**Notice of Exhibition of application for SSI 10041 – Redfern Station Upgrade – New Southern Concourse**

Thank you for your referral (26 May 2020) inviting comments from the Heritage Council of NSW on the above State Significant Infrastructure (SSI) proposal.

**Tim Smith OAM**  
Director Heritage Operations  
Heritage NSW  
Department of Premier and Cabinet  
**As Delegate of the Heritage Council of NSW**  
2 July 2020

Figure 15 Section: Option 1 - Perforated Screen

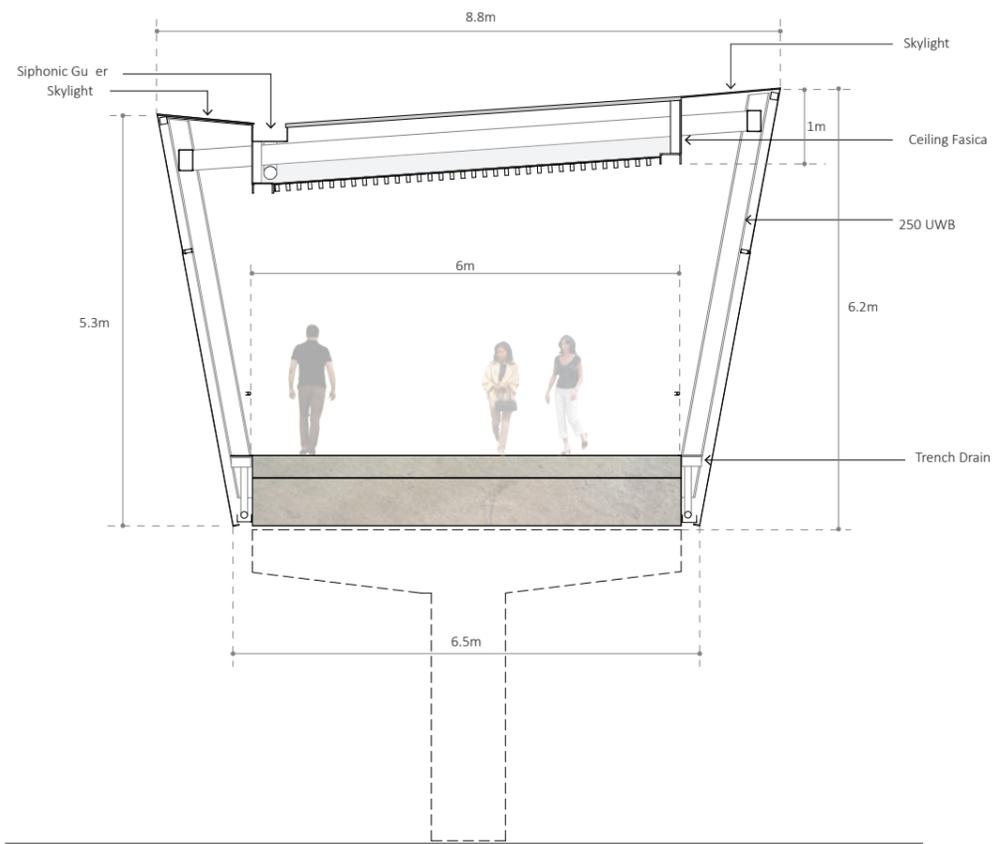
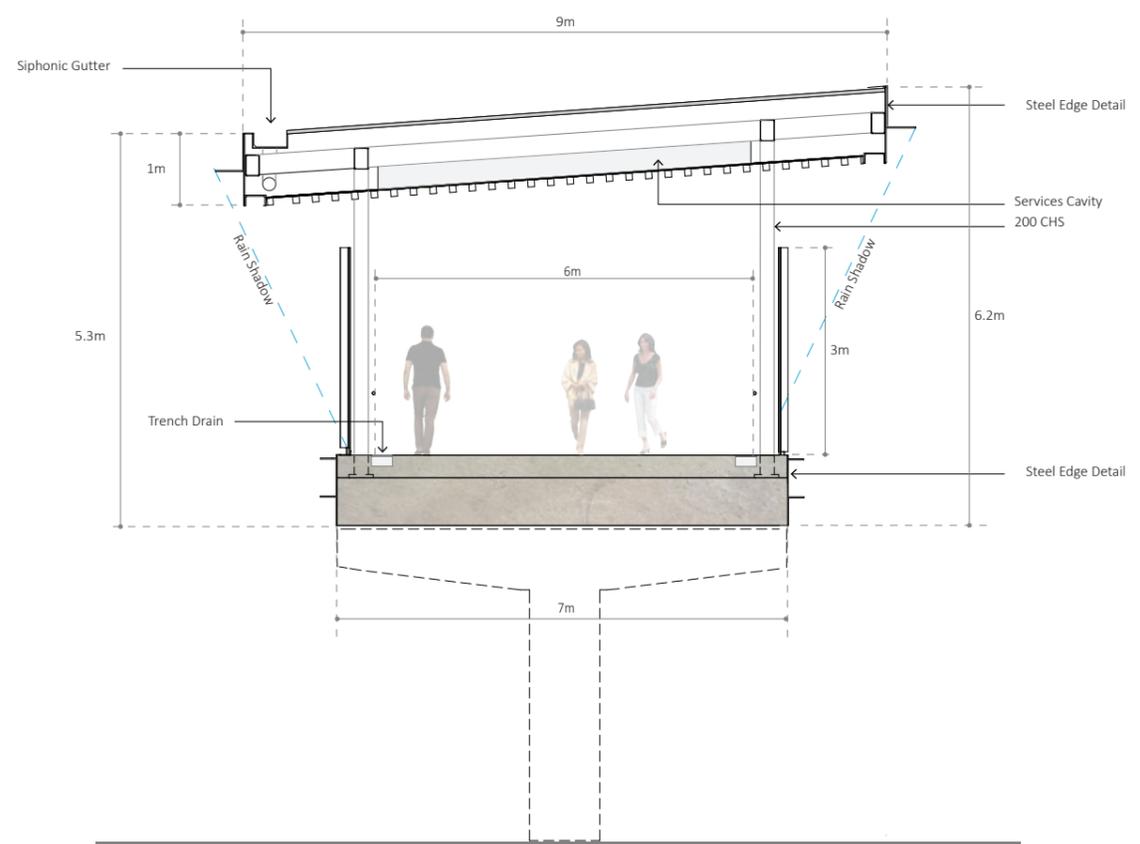
- Modify the mesh screening to maximise the level of transparency and light weight character of the structure;
  - Increase the glazed viewing panels on the concourse to enhance views to the full extent of the ERW site;

Figure 18 New Southern Concourse Plan

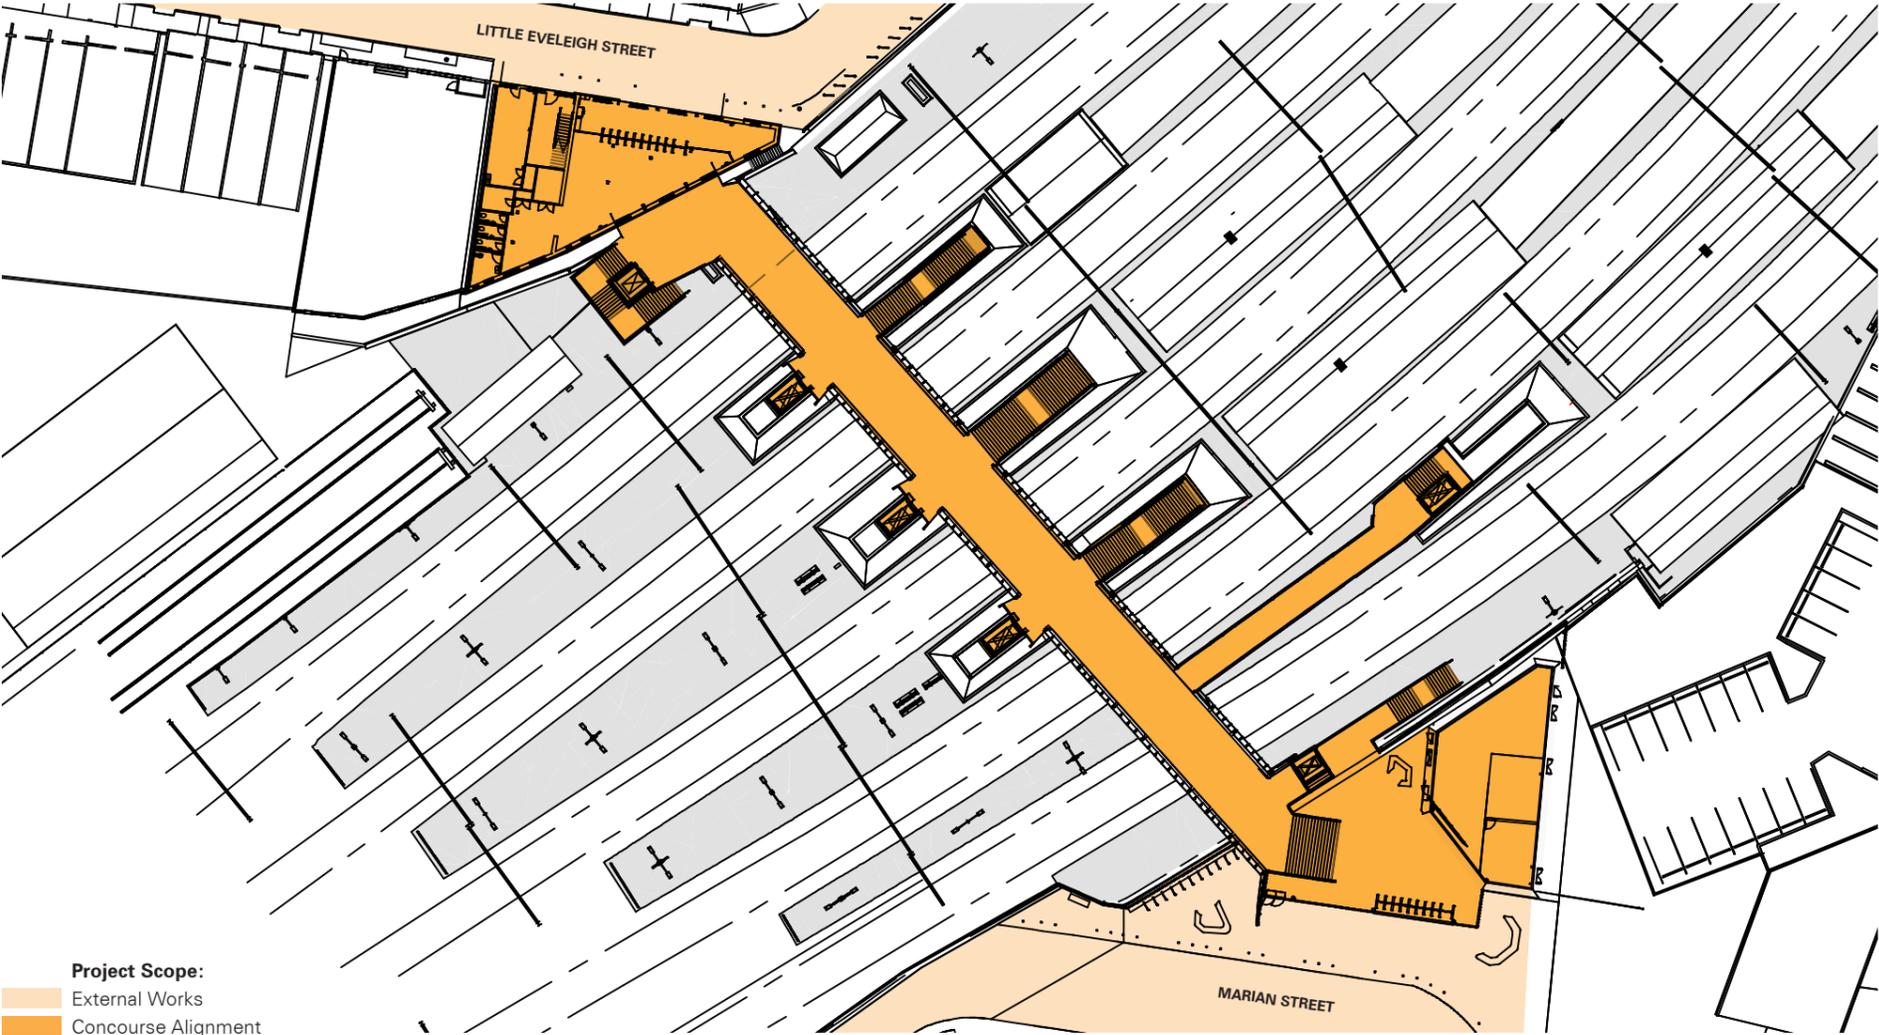
- It is noted that the proposed concourse (including lifts and stairs) would be positioned directly over existing platforms on the southern end of the station, with the new stair landings terminating near existing platform buildings. Whilst Heritage NSW understands that TfNSW have identified this placement to minimise the structure's dominance on the sensitive platform areas, it will again diminish the open spatial characteristic of the southern end of the station and the setting of the platform buildings. The new concourse will be a dominant visual feature in the landscape, in particular against the singular level platform buildings.

- Whilst acknowledging that multiple options for the location and alignment of the new concourse were explored and that efforts have been made to moderate the heritage impacts of the proposal, further design development is required to reduce the bulk and scale of the proposal. Recommended changes include.

- Reducing the height of the structure to lessen its visual dominance in the landscape;
  - Simplify the structural framing for the concourse and support structure (and minimised where possible) to reduce its visual dominance;

Figure 29 Little Eveleigh Street Concourse - Plan

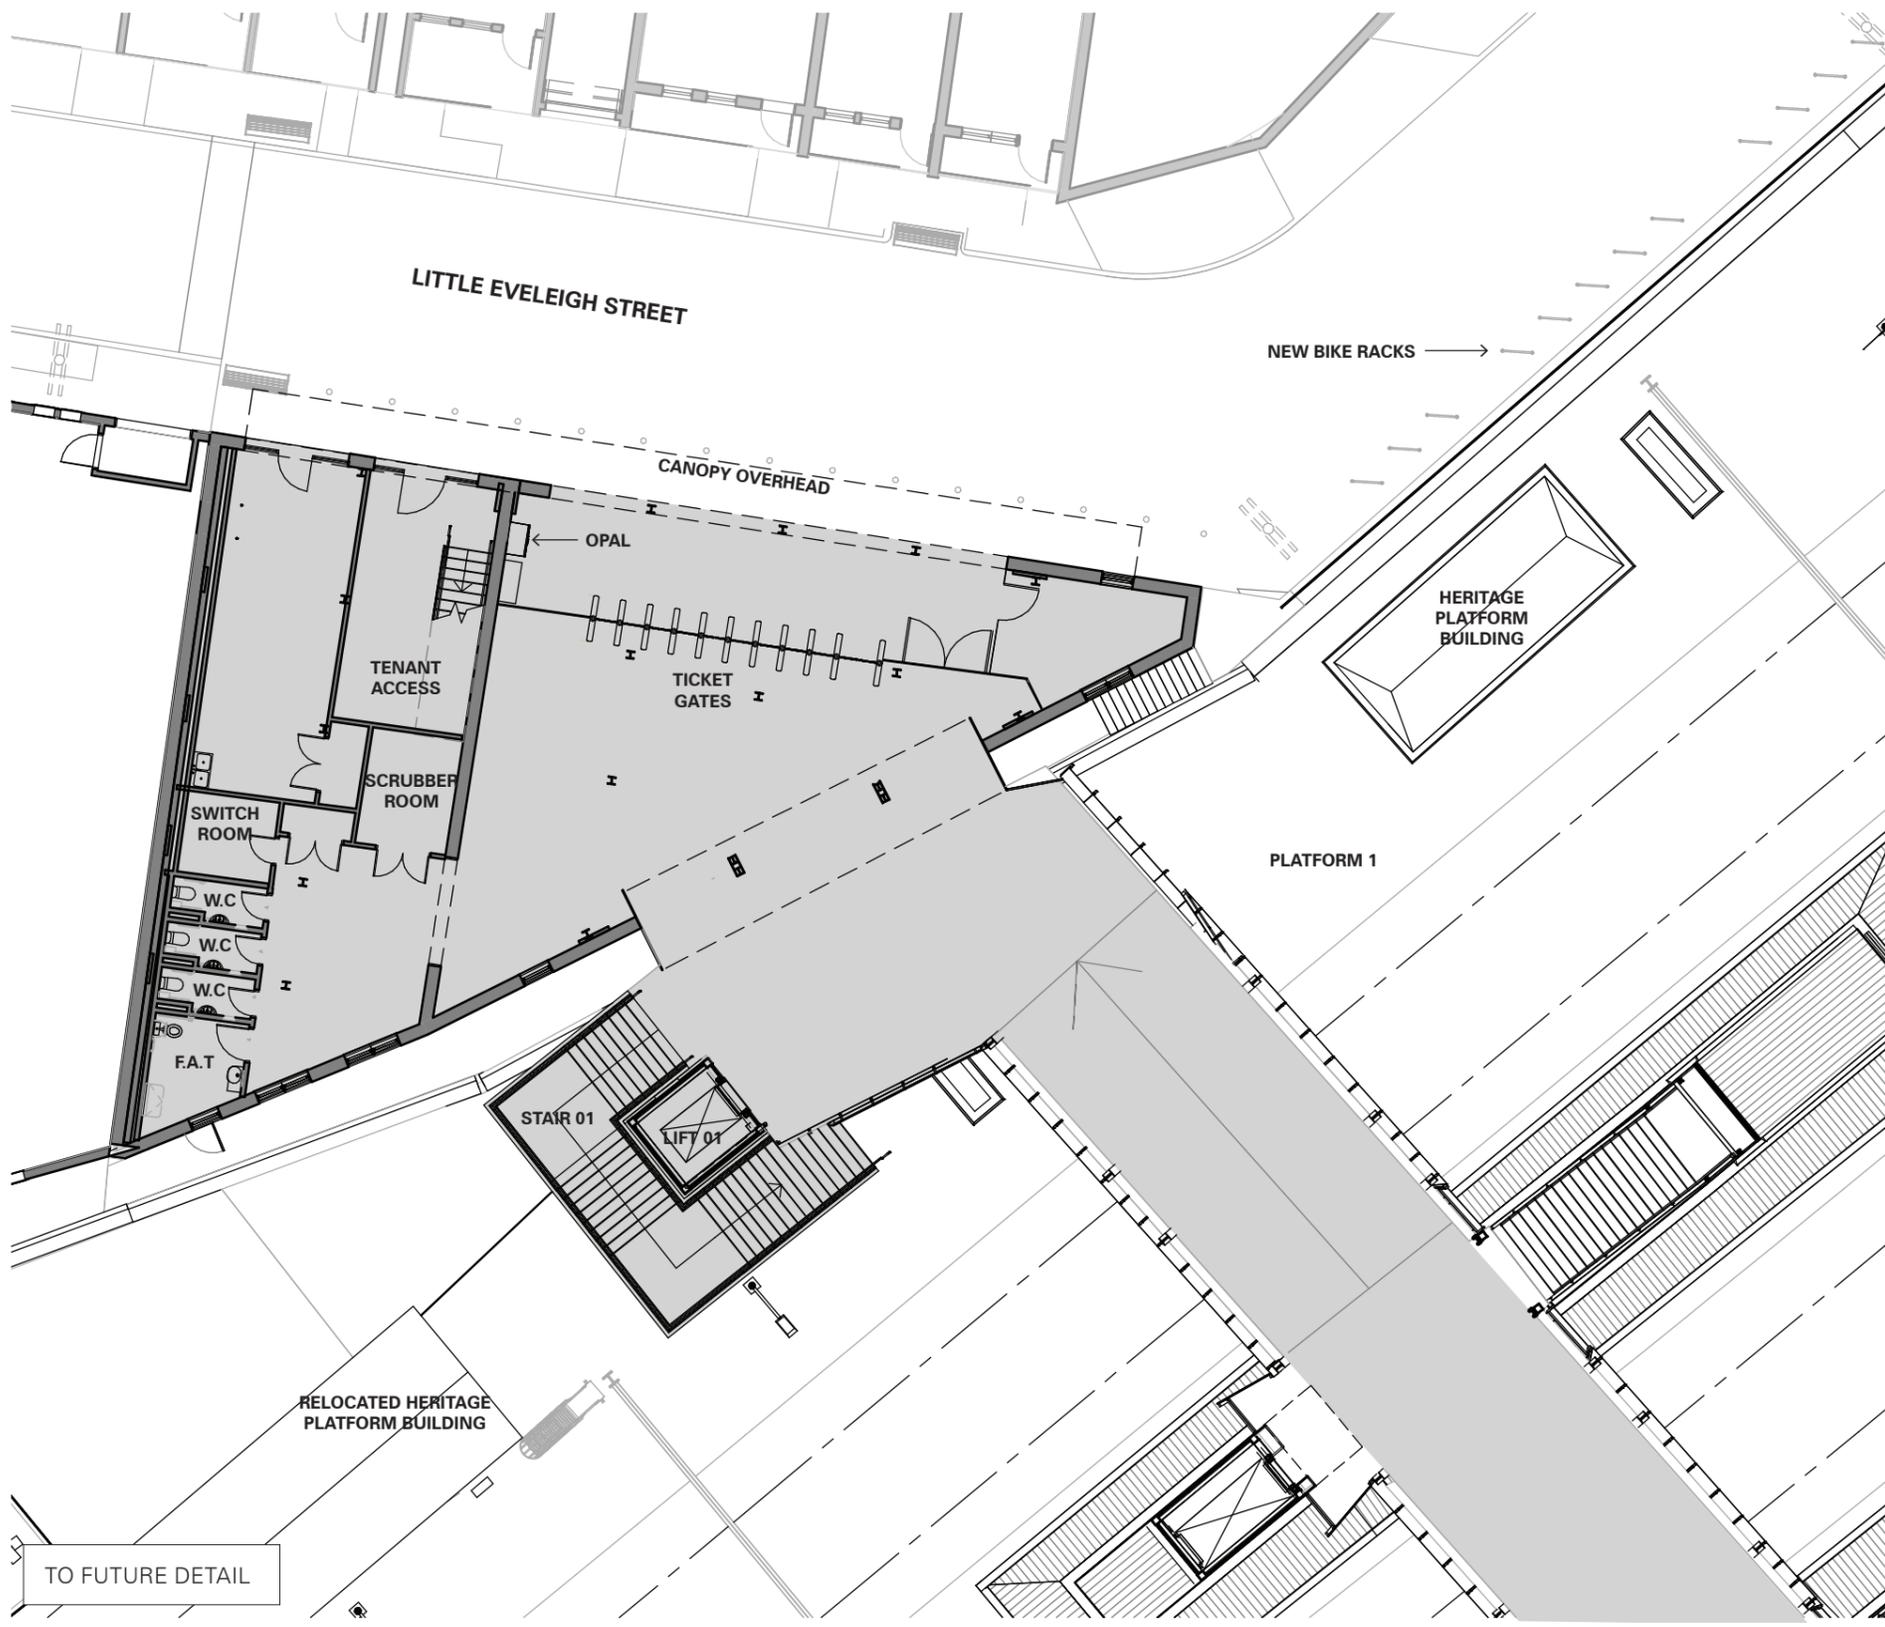
- The retention and adaptive reuse of the warehouse building at 125-127 Little Eveleigh Street as a new station entrance is strongly supported. This will assist in retaining the character of the surrounding streetscape. However, further detail is required to better understand what fabric will be retained and how the new concourse will connect with the existing building. In addition, further detail is required to understand the proposed internal works to the building to ensure adverse impacts to fabric and spatial arrangements are minimised.
